Application Ref:	2025/0063			 Ribble Valley Borough Council <small>www.ribbonvalley.gov.uk</small>
Date Inspected:	N/A	Site Notice:	N/A	
Officer:	EP			
DELEGATED ITEM FILE REPORT:				APPROVAL

Development Description:	Non material amendment to application 3/2025/0231 involving the movement of a proposed rear door and window.
Site Address/Location:	3 Church Street, Clitheroe BB7 2DD.

**03-204 - General-Arrangement\_Plans\_Sheet-02 Proposed Elevations**

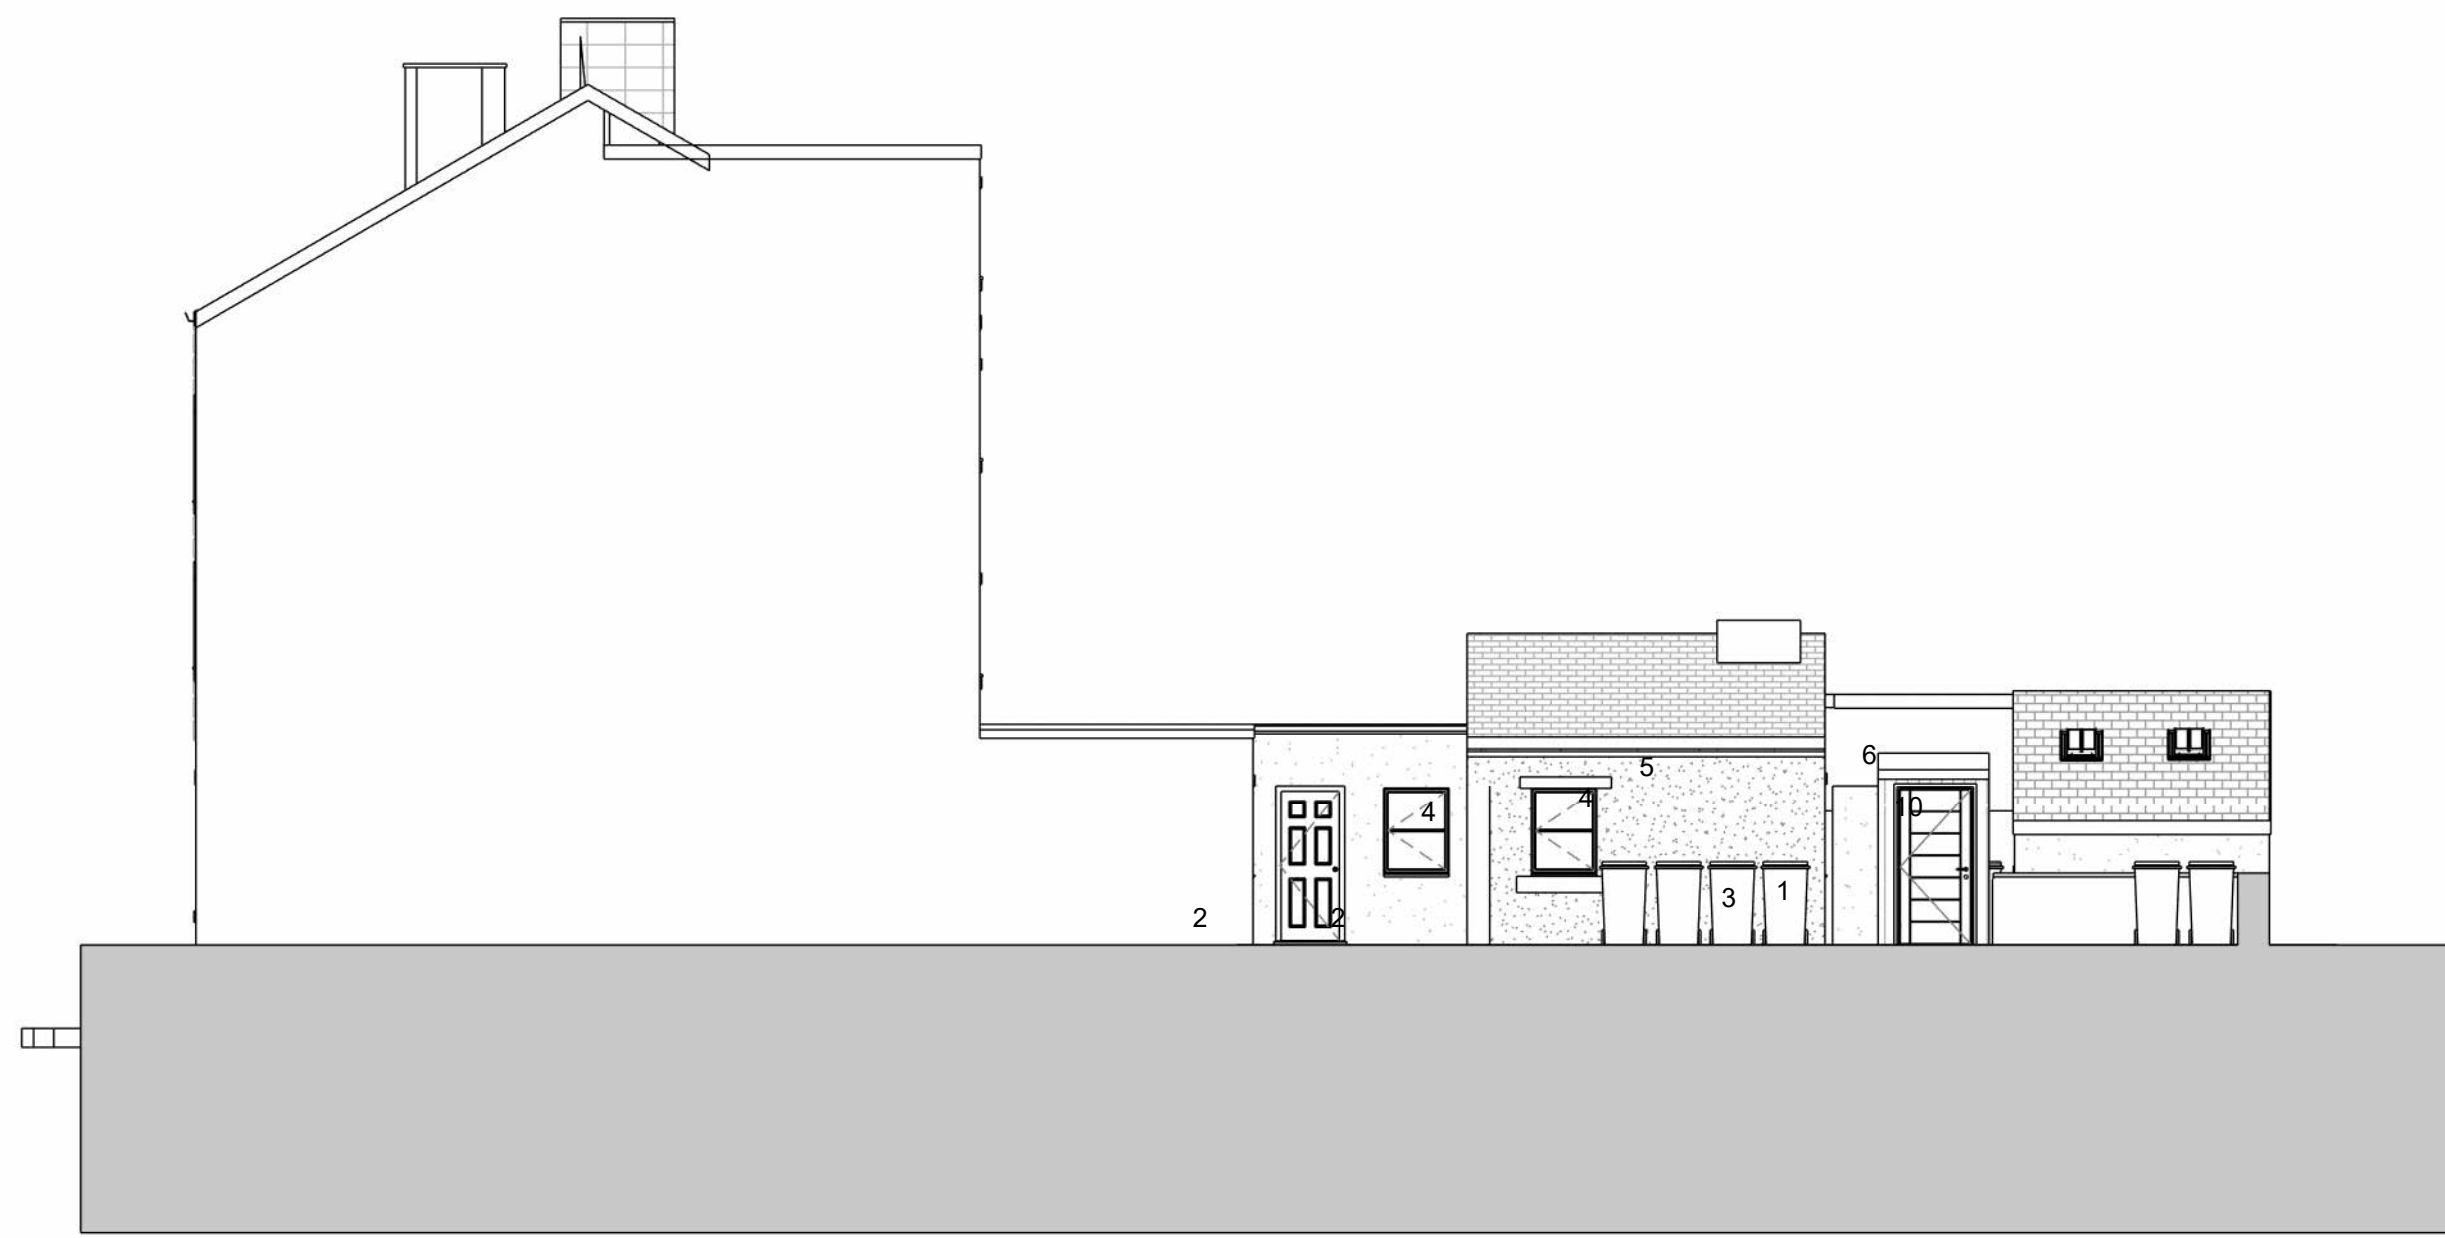
The amendment sought relates to the alteration of the approved single storey extension and not to the fabric of the listed building itself. It is proposed that the approved window opening in the side elevation of the extension will be relocated to sit further north to accommodate the addition of a side access door within the single-storey extension. It is not considered that these alterations significantly alter the visual appearance of the building or would be of harm to the character of the listed building. As such, the proposed change is non-material in nature and considered acceptable.

That the non-material amendment be approved.
